RE: Nathan Clifford Redevelopment – Portland, Maine

Following are responses to your comments on our team's application for permit:

Consultant:
ARCHETYPE architects
48 Union Wharf Portland, Maine 04101
(207) 772-9022 ARCHETYPE@ARCHETYPEA.COM

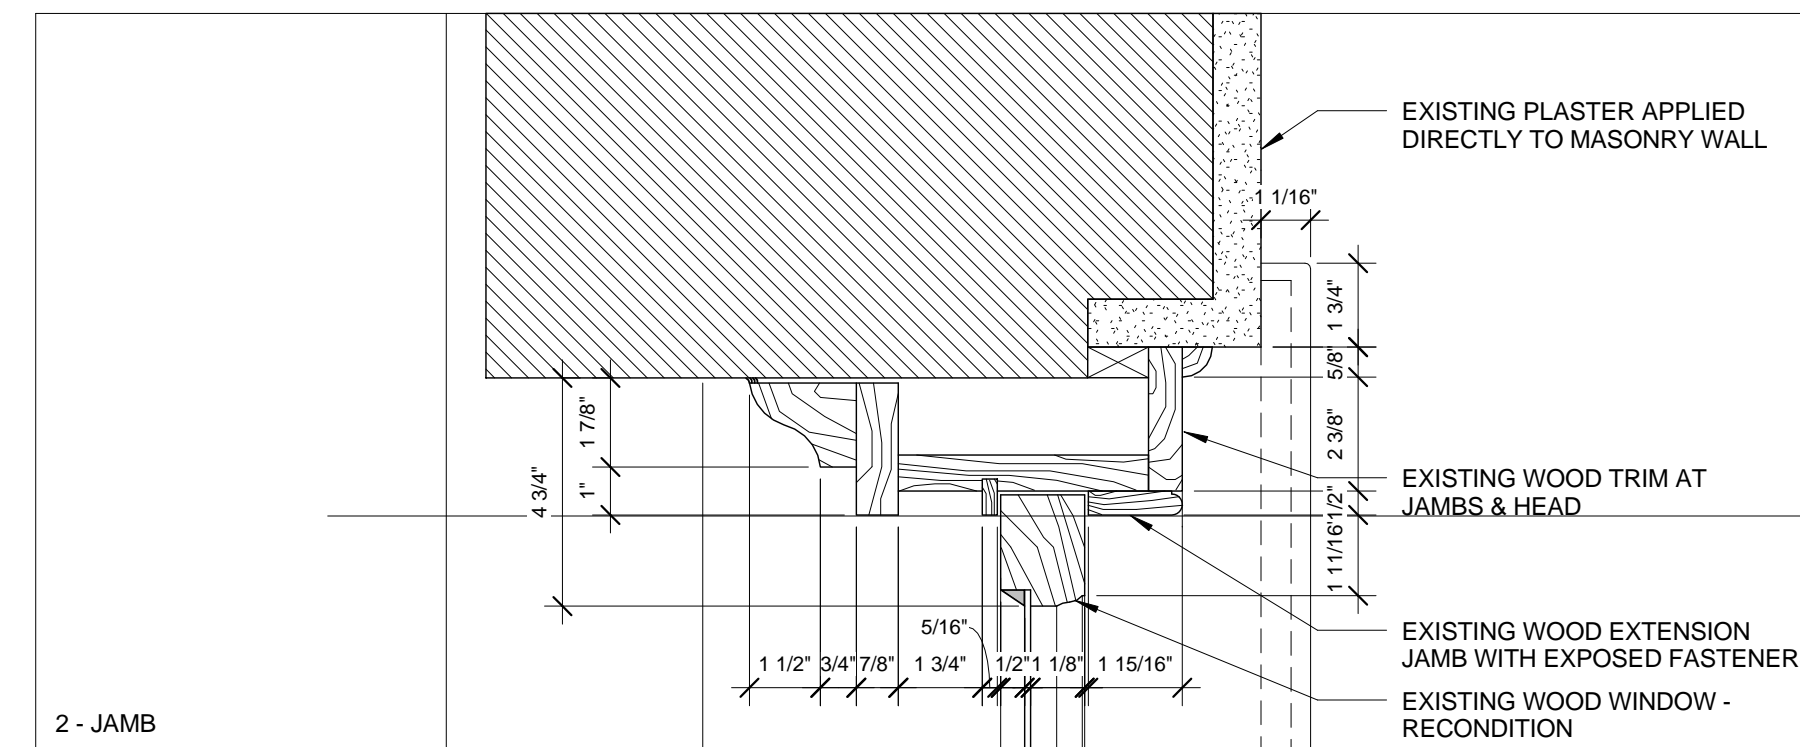
“Window Glazing/Transoms

See Table 1018.1 for corridor partitions allowed to be .5 hour and Table 715.5 for window ratings in fire partions to be 1/3 hour, 20 min.”

Response: Transoms in historic buildings are not required to comply with assembly requirements of this code.

“Section 3409.1 Historic buildings. The provisions of this code relating to the construction, repair, alteration, addition, restoration, and movement of structures and change in occupancy shall not be mandatory for historic building where such buildings are judged by the building official to not constitute a distinct life safety hazard.”

It is our view that the NFPA 43.10.4.5 specifically exempts existing transoms in historic buildings. In addition transoms will be sealed to prevent smoke movement; therefore we feel this does not create a distinct life safety hazard.

Amended Response: Though allowed by code, it has been requested by Captain Pirone that we take a second look at the proposed transom conditions to remain. Upon further review, we have documented in four locations, the transoms to remain in the proposed corridor have previously infilled with wood panels and are no longer glazed. The attached sketch shows additional layers of gypsum applied to the transom panel to provide the required rating. Also shown in the attached sketch, the half lite wood door at these same locations, previously proposed as to remain, are called for to be removed and replaced with a rated unit door or fixed in place and fortified with an infill rated wall at the unit side. All other existing doors and transoms to remain are not located in proposed corridor walls.
